Sub plans

This email is regarding the proposed development at 15 Warren Crescent, East Preston. My Team Leader will be unable to review the proposal until the 20<sup>th</sup> of November, if you are able to agree an Extension of Time until this date, it would be appreciated.

1422/P02

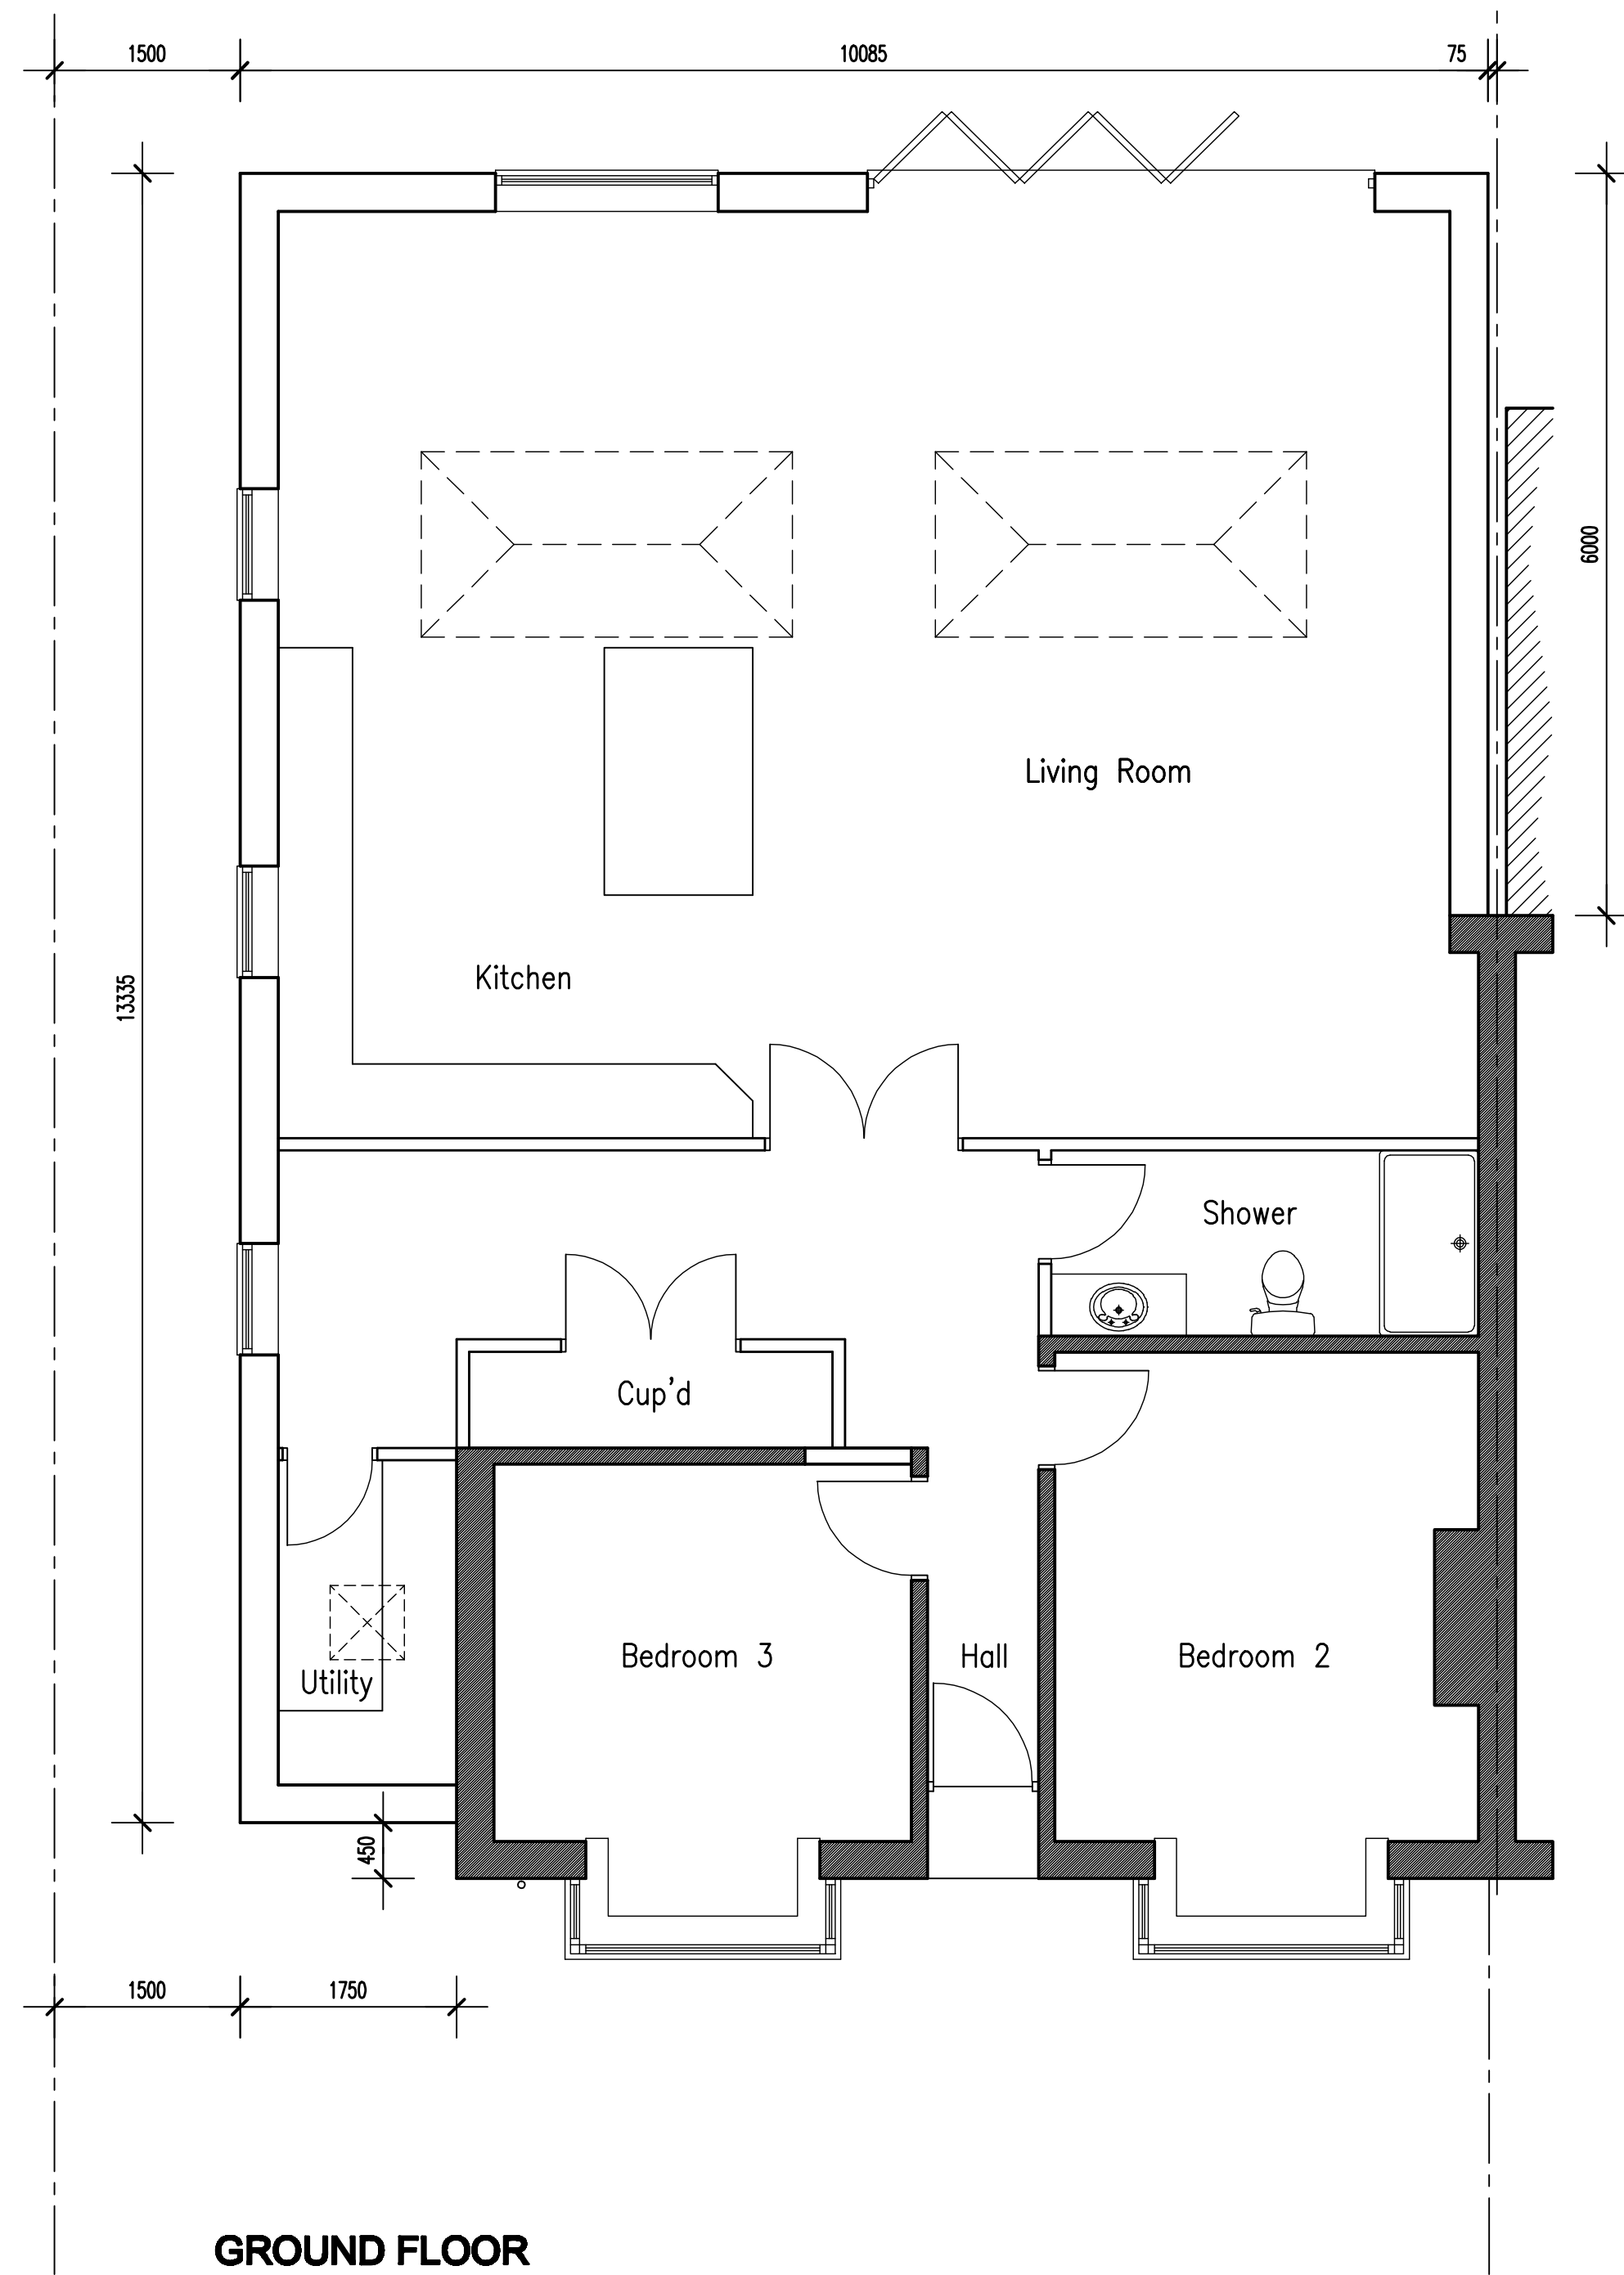
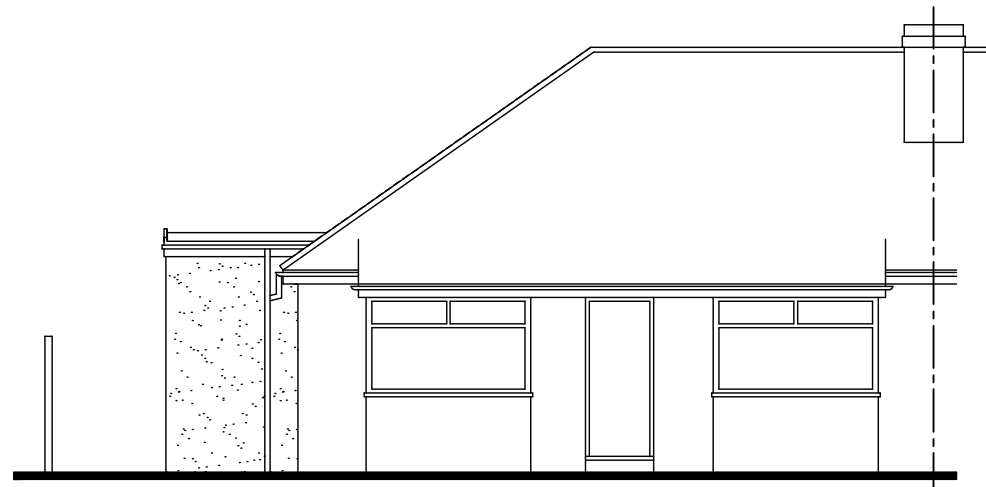
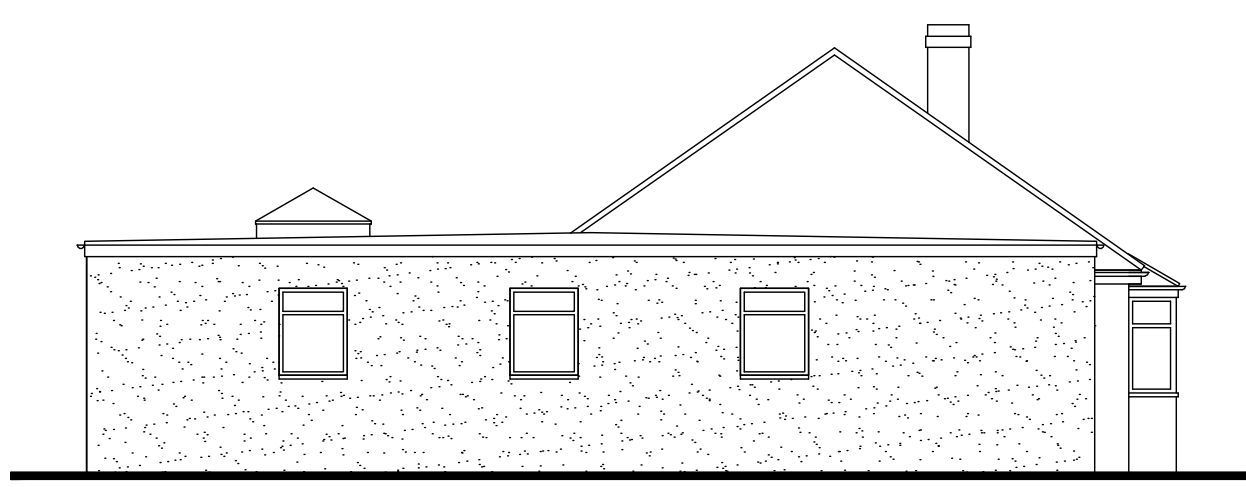
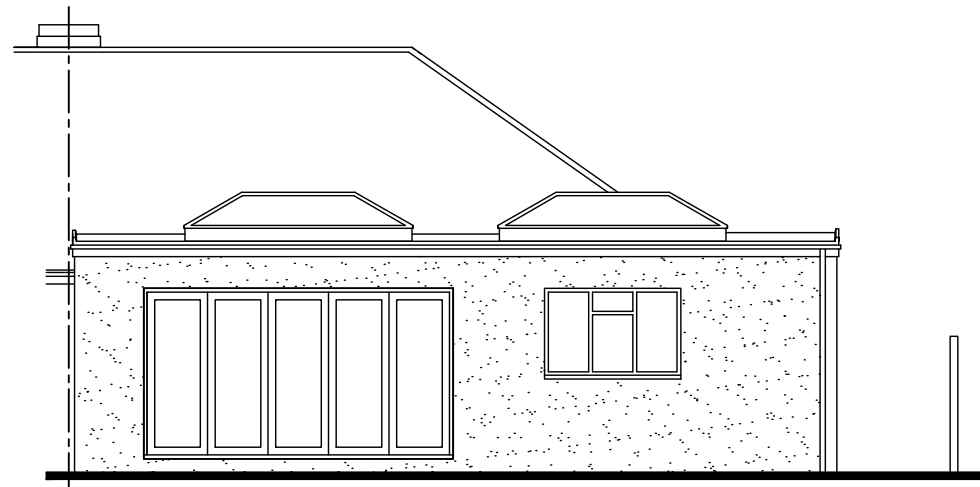
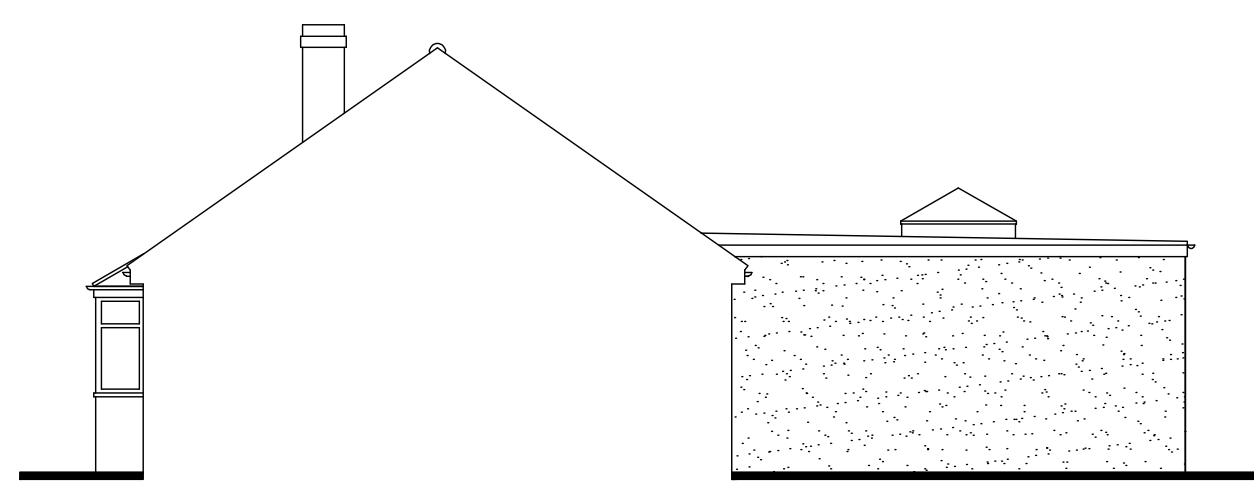
Unfortunately, the 0.5m reduction is not acceptable, if you are able to amend the drawings to be more inline with my previous comments, then this would be appreciated. Alternatively, if you have any other proposals, I am happy to consider these.

However, it is believed that amendments could be made in order to create a scheme that was looked upon more favourably by the LPA. These would be a 1m reduction in length of the rear extension, and a 2.5m reduction of the side element of the extension, away from the street scene.

We have reduced the rear extension by 1 metre as requested however we have reduced the side extension by 0.5 metre in order to maintain the internal utility room. This setback provides a distance of 950mm from the existing frontage which is sufficient to make the new extension appear to be subordinate to the existing bungalow.
